Attached please find the archaeological observations/recommendations of the Department in relation to the aforementioned Application for substitute consent at Athgarrett, Philipstown and Redbog, County Kildare.

Your Ref: ABP-319218-24
(Please quote in all related correspondence)

Re: Application for substitute consent for quarrying and aggregate extraction at Athgarrett, Philipstown and Redbog, County Kildare

Figure 10-1. The EIA study area is indicated with the purple line. RMPs are indicated with black circles and SMRs with blue circles.

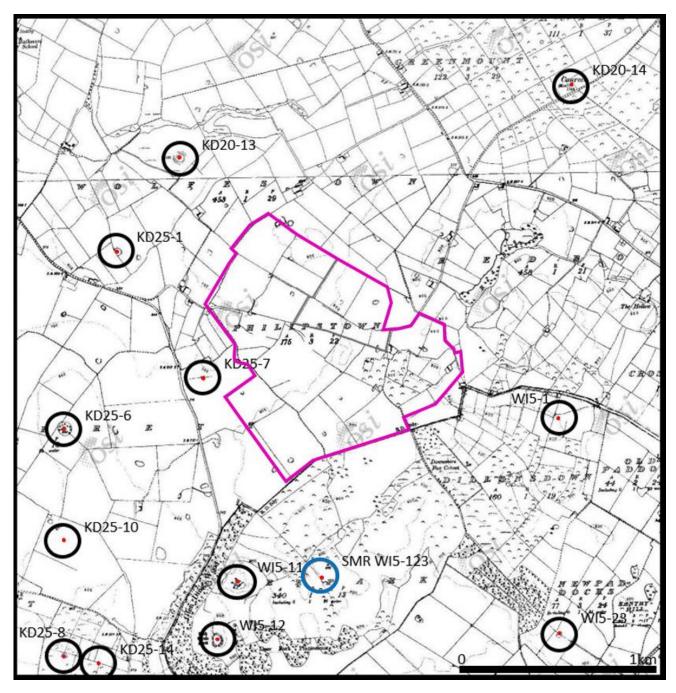
3. A suitably qualified archaeologist shall be retained to advise on, and establish appropriate Exclusion Zones around the external-most elements of non-Statutory SMR site WI005-123---- (Deer park).

- a. The Exclusion Zones shall be fenced off or appropriately demarcated for the duration of construction works in the vicinity of the monuments. The location and extent of each Exclusion Zone and the appropriate methodology for fencing off or demarcating at each location shall be agreed in advance with the Department and the Planning Authority.

- b. No groundworks of any kind (including but not limited to advance geotechnical site investigations) and no machinery, storage of materials or any other activity related to construction will be permitted within the Exclusion Zones.
